April 22, 2008

RE: 1350 Washington Avenue – 344-C-005 – R-P Residential Professional Zone –
Sign permit application # 08-0351

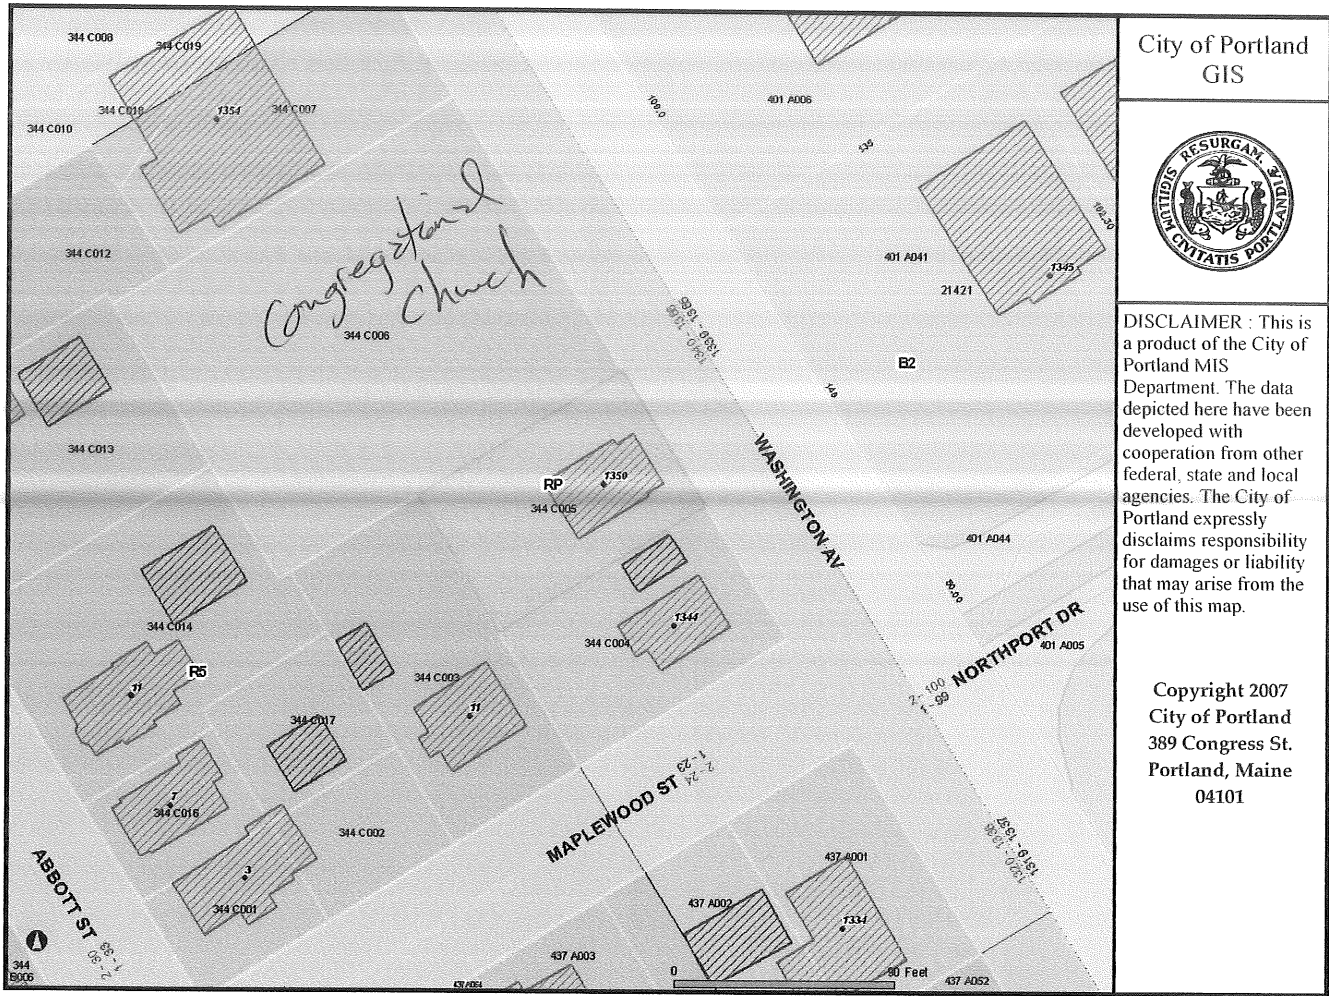
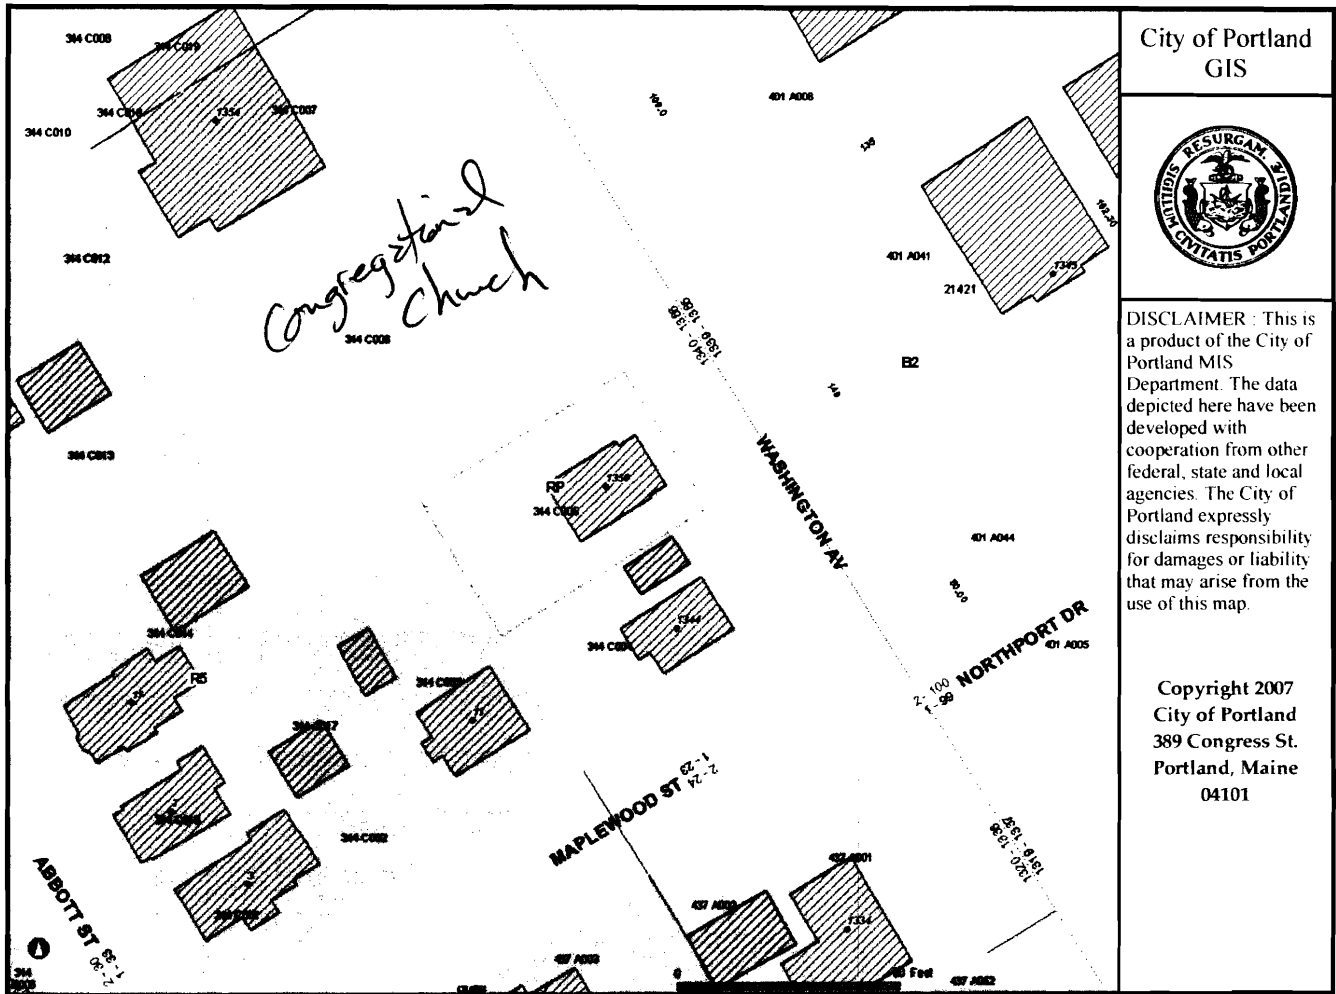
This office recently received an application to install a new free-standing sign at 1350 Washington Avenue which is located in an R-P Residential Professional Zone. Table 2.3 of the sign ordinance states that only free-standing signs are allowed. A visit to your property at 1350 Washington Avenue showed two building signs attached to the building. Our records show no permits were ever taken out for those building signs. The illegal building signs must be removed within thirty (30) days of this letter.
